CONSULTEE RESPONSE (Arun District Council - Arboriculturist)

Reference: WA/51/26/RES

Proposal: Approval of reserved matters following the grant of outline planning permission WA/35/23/OUT, for the construction of 95 no. new homes, access, new pedestrian and cycle links, open space, landscaping, habitat creation, drainage features and associated groundworks and infrastructure, including details relating to the Sensitive Lighting Strategy, POS details and Part M Compliance. This application is in CIL Zone 3 and is CIL Liable as new dwellings.

Location: Land East of Wandleys Lane, Fontwell

TREE PROTECTION PLAN: (12753 TPP 01 Rev A)

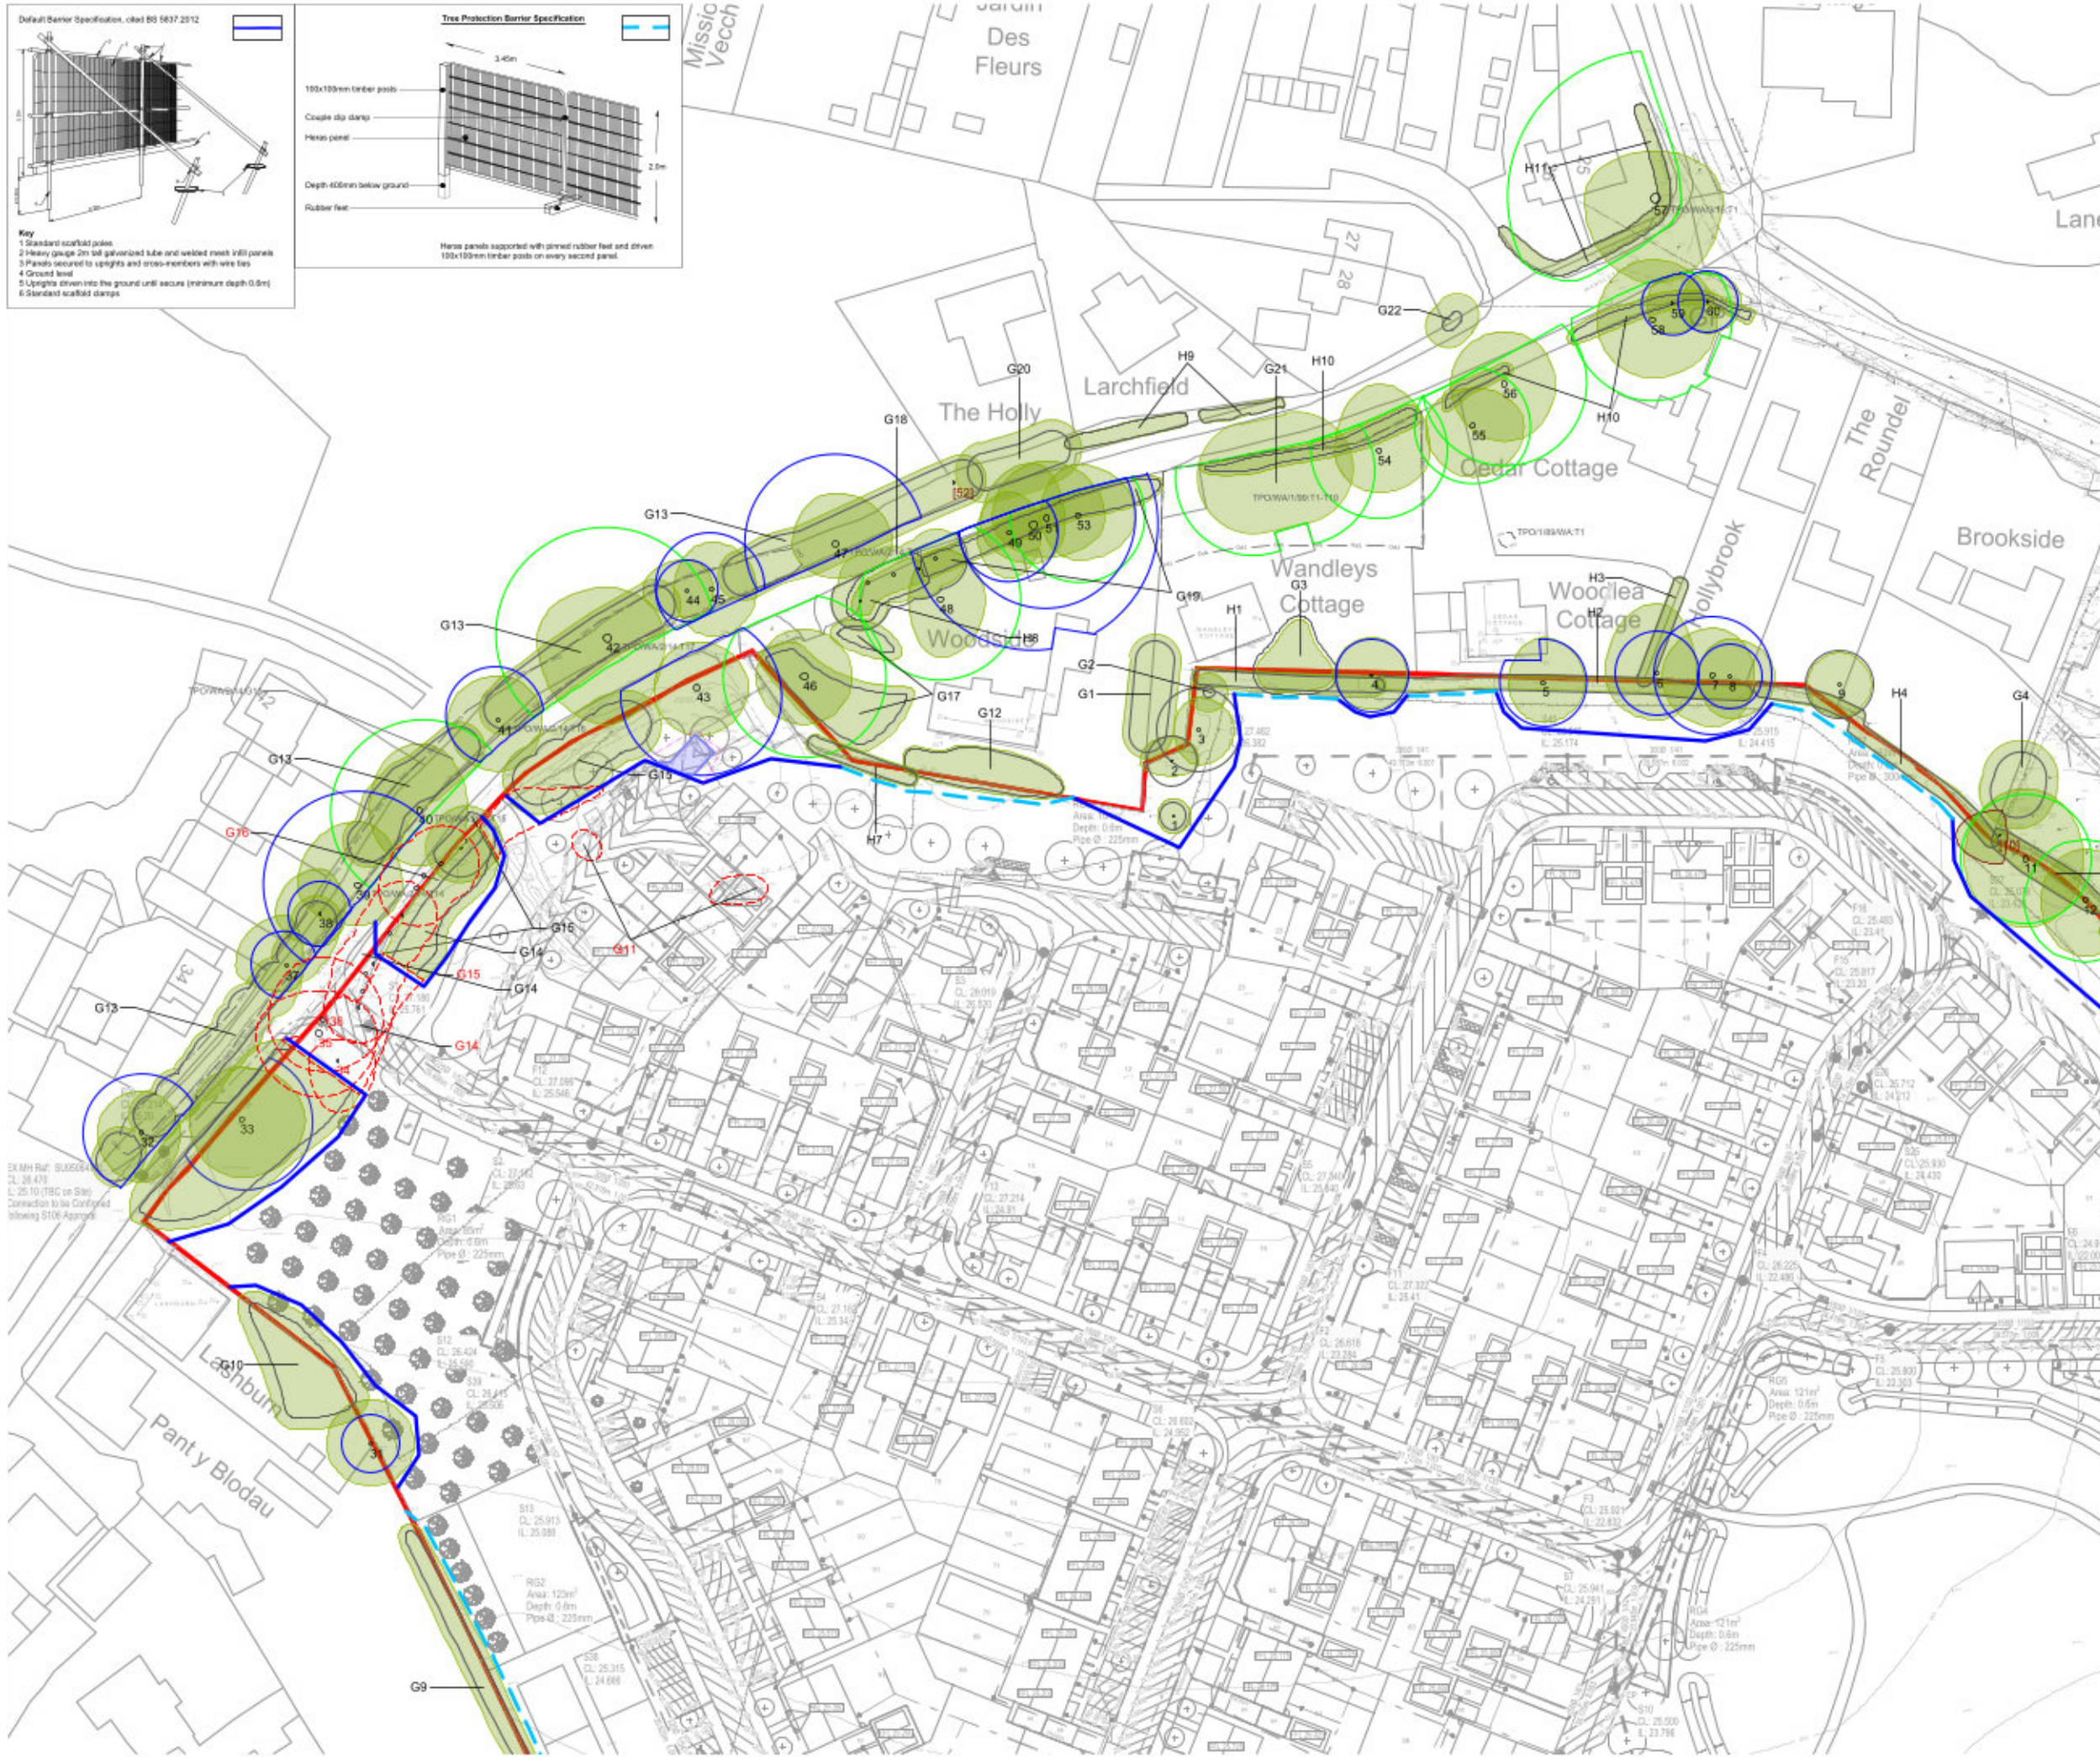
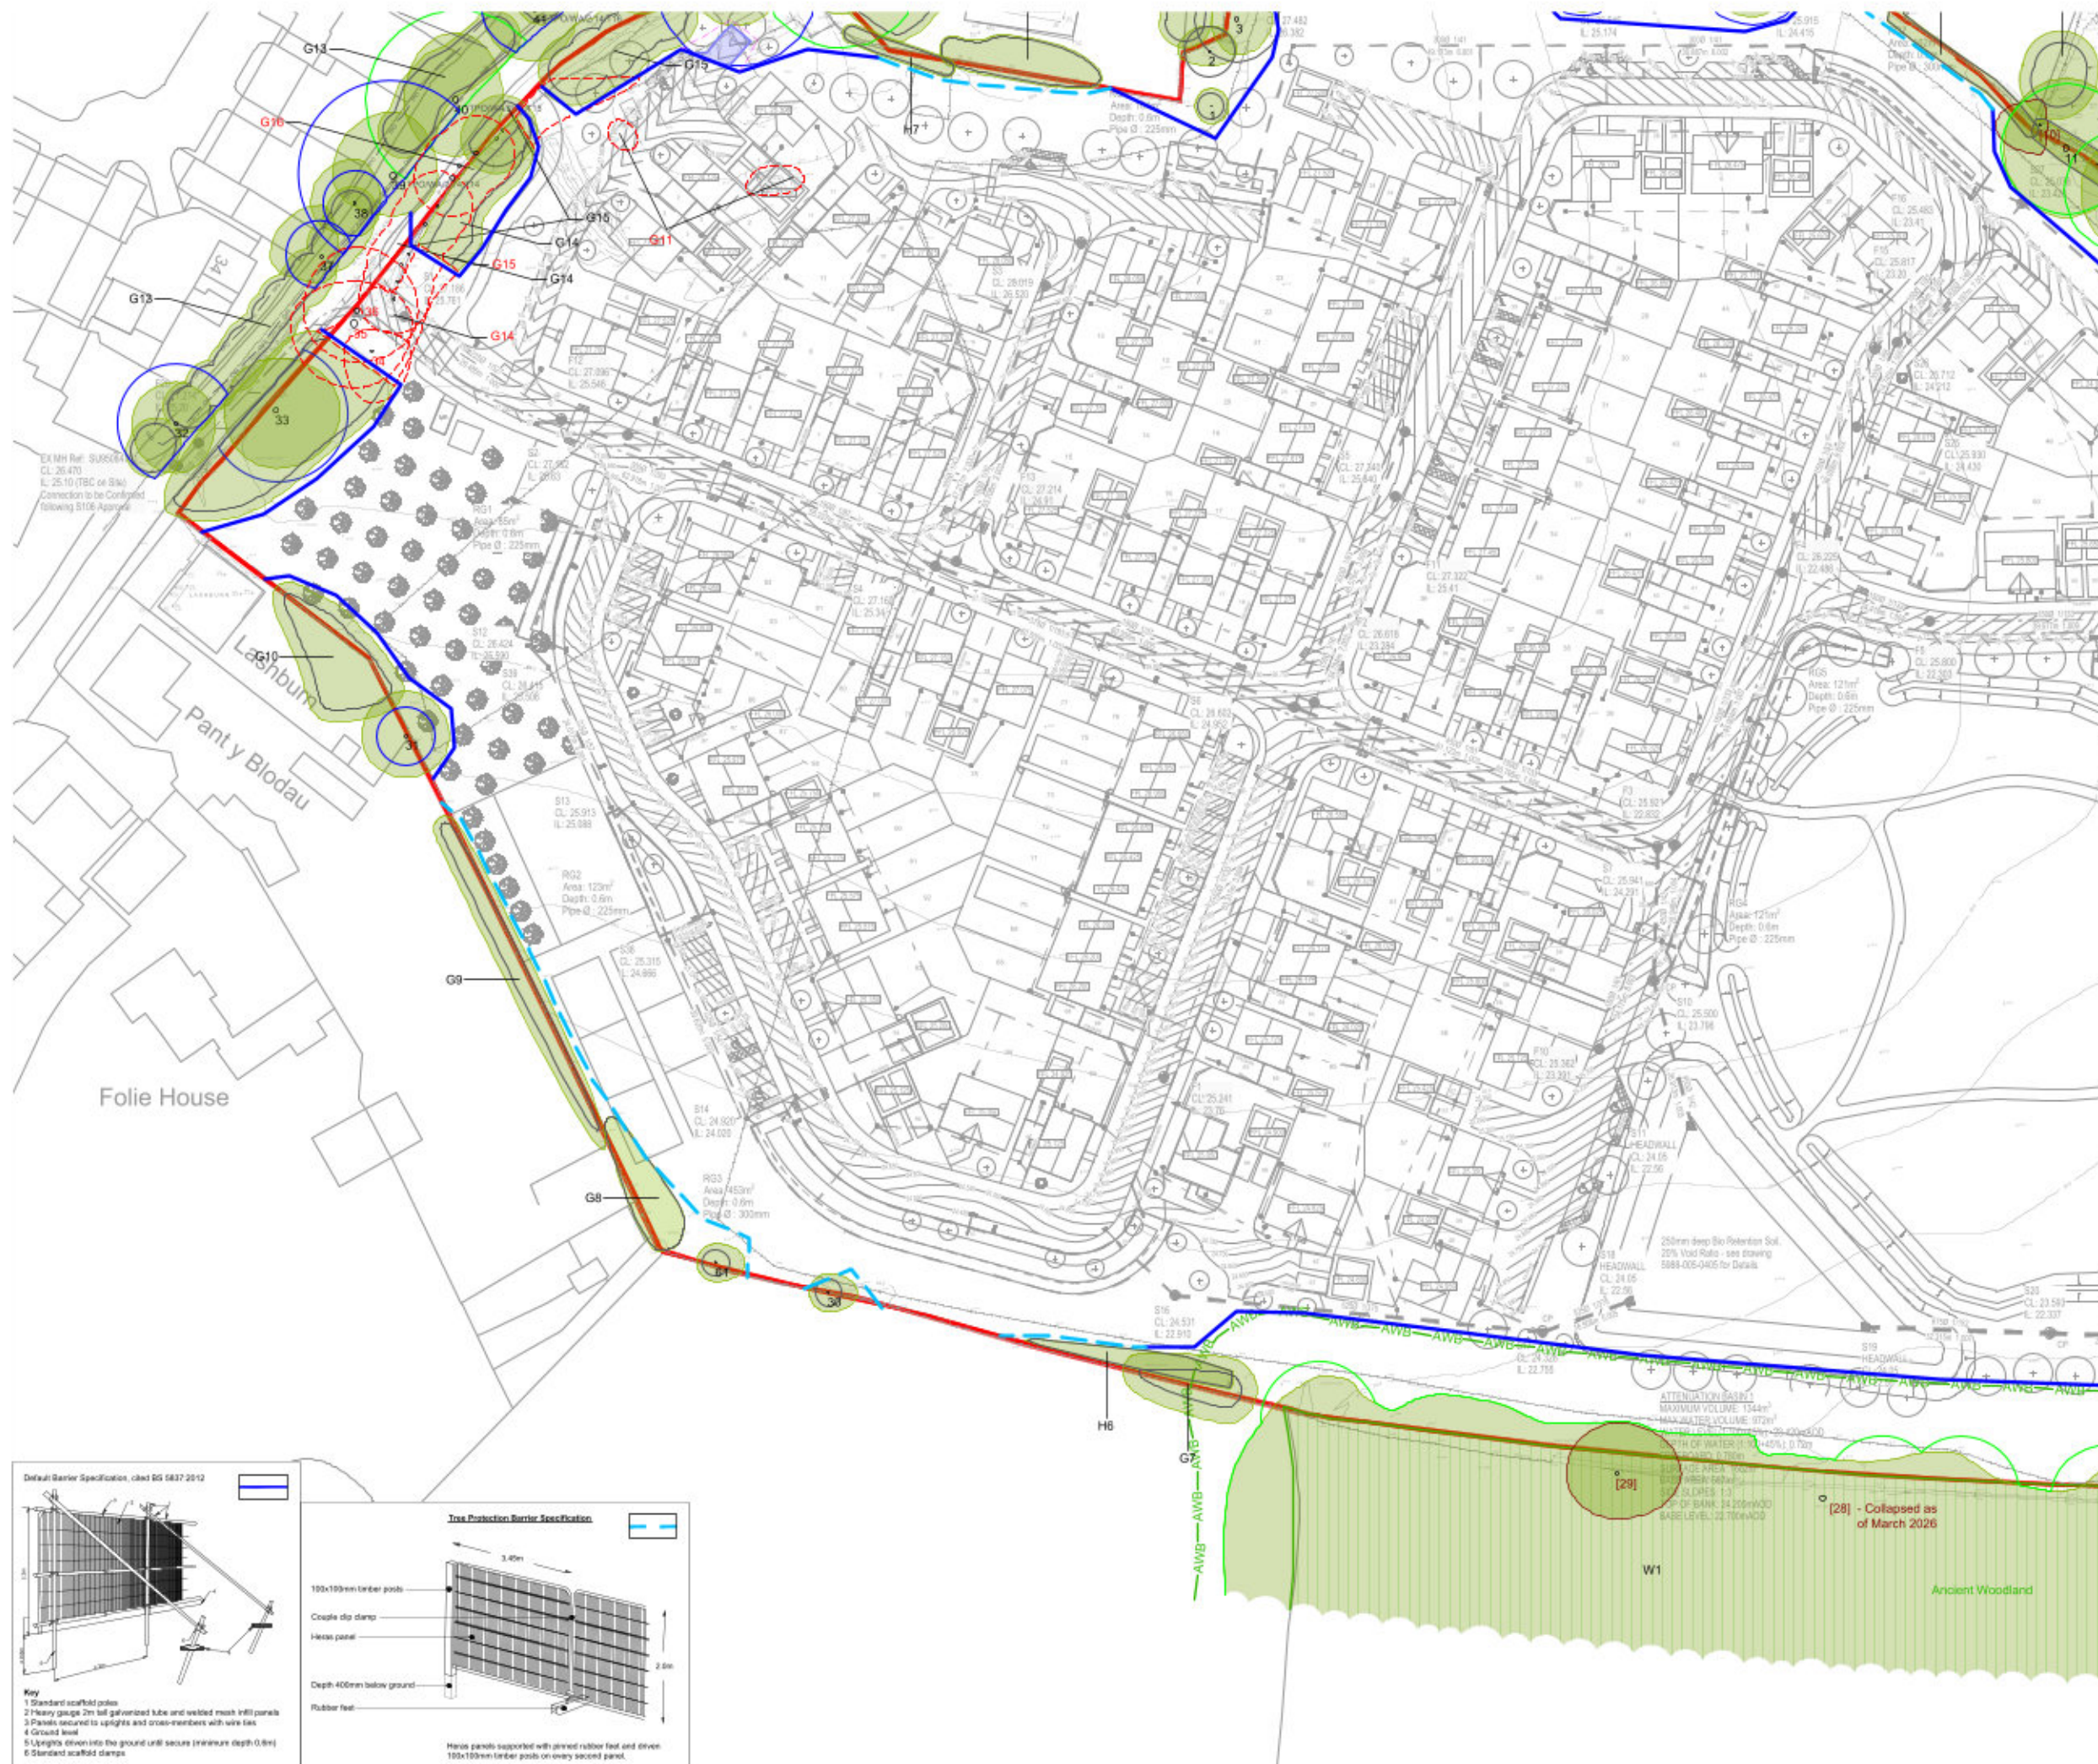
There is no mention in the AMS of TPO/WA/1/24, which affects individual oak trees T18, T19 & T23 (their refs.) and TPO/WA/1/23 a woodland order which affects the whole of Wandleys Copse (ref. W1). Those individuals may be referenced on a TPP but I cannot confirm due to the poor resolution under magnification of the copies available to me.

1. Dwellings, supporting road network and surface water drainage infrastructure is proposed adjacent the AWB. Indeed, both attenuation basins 1 & 2 are partly within.
 2. Changes to the water table or drainage. Drainage Plans suggest the existing exceedance flow across the site is toward the south and east, affecting both habitats and important trees (TPO).
 3. RPA +2m buffer - incursion from construction.
 4. Increasing levels of air and light pollution, noise and vibration
-
5. Increasing disturbance to wildlife, such as noise from additional people and traffic
 6. Increasing the amount of dust, light, water, air and soil pollution
-

A buffer of 2m beyond their calculated RPA should be implemented for trees T11 – T25, if they have not been afforded veteran tree status. This to ensure no construction creep during the creation of attenuation basin 2 and demand a relocation of proposed subterranean utility apparatus to outside of this greater construction exclusion zone (CEZ).

The construction of swales within the AWB is incompatible with guidance.
